KITTTITAS COUNTY COMMUNITY DEVELOPMENT SERVICES

RE: Mayr Parcel Combination (CB-20-00005) - Deemed Incomplete

Combine 951338 & 951339 into a parcel  
951339

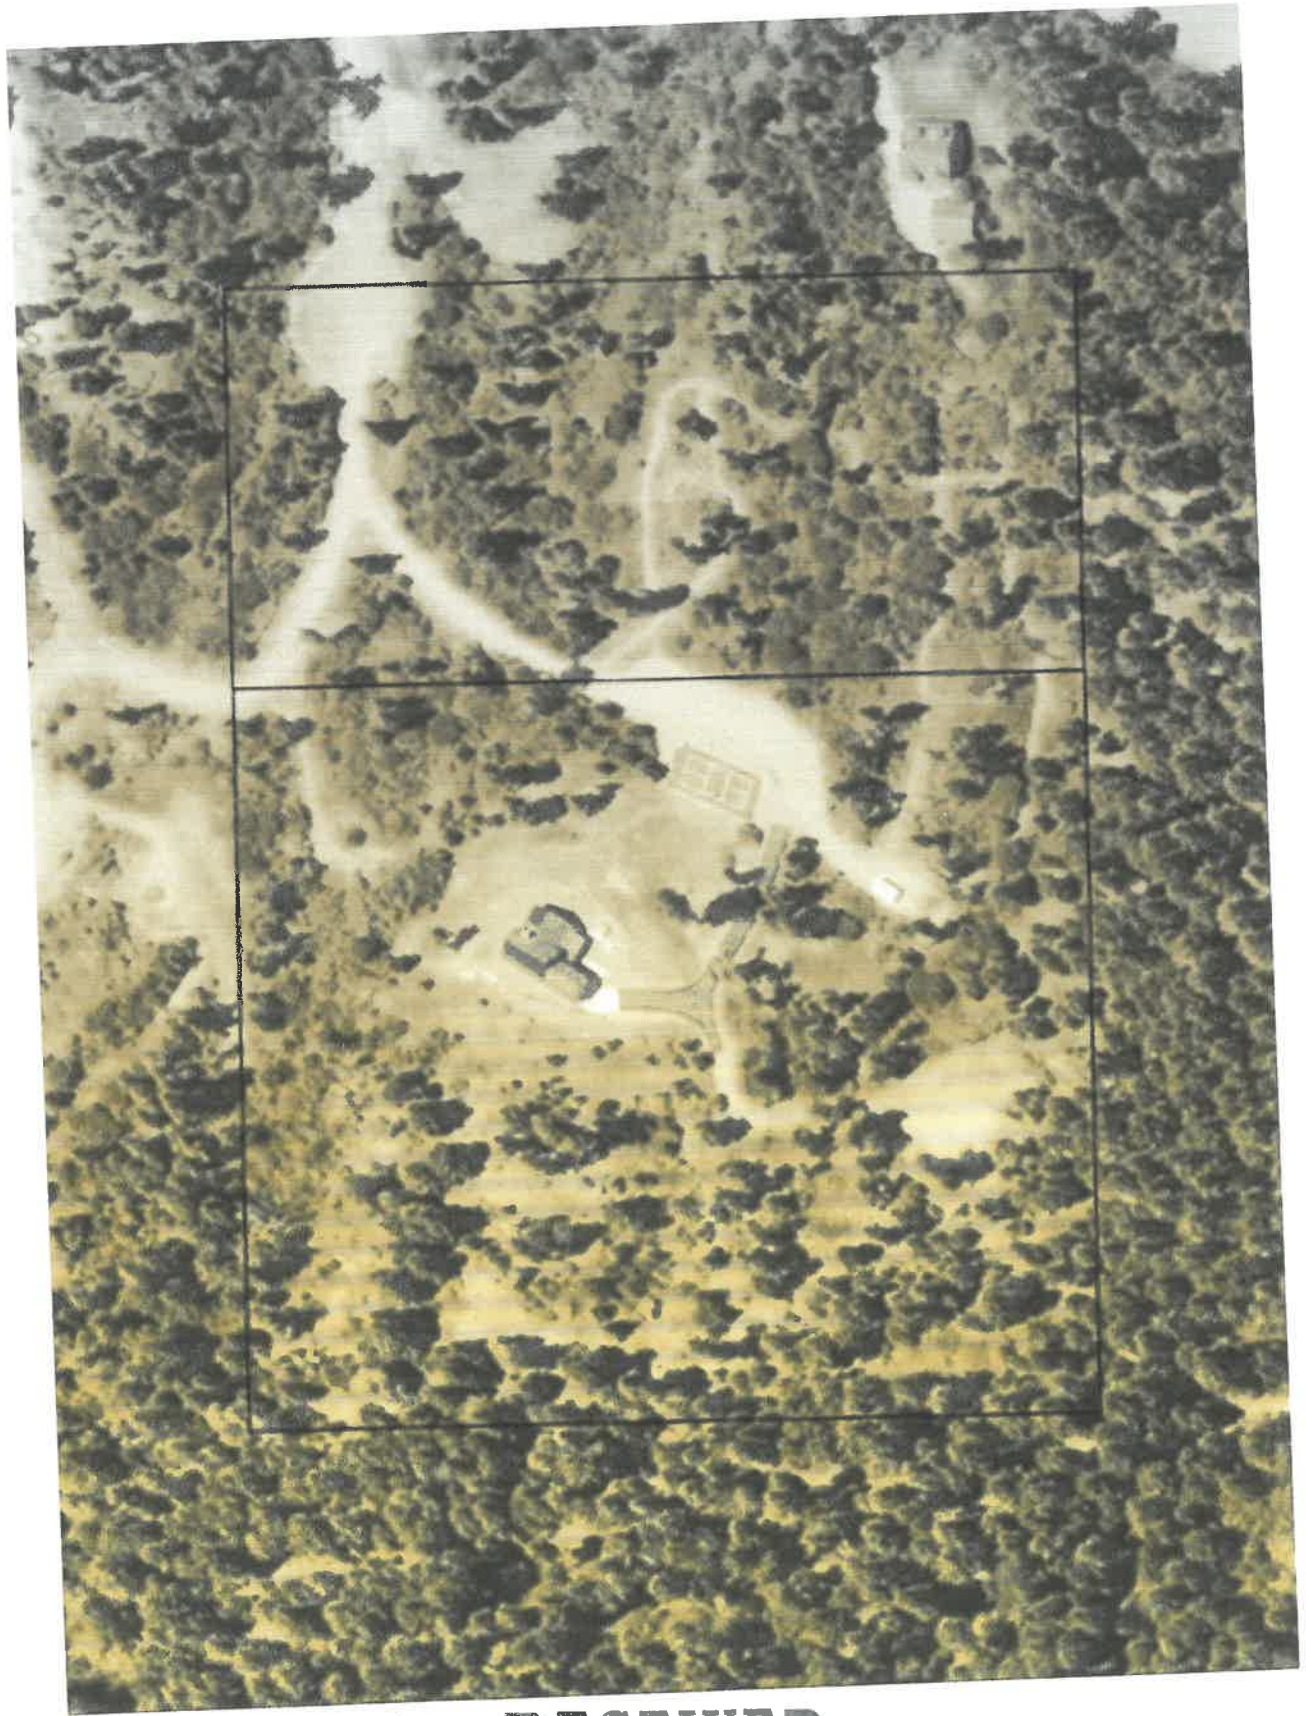
1. Legal descriptions of the proposed lots.
2. Your unified site plan currently shows the existing structures and drainfield. However, we will need an updated site plan also showing access points and well head (s) with distances marked.
3. Project narrative description including at minimum the following information: project size, location, water supply, sewage disposal and all qualitative features of the proposal; include every element of the proposal in the description.
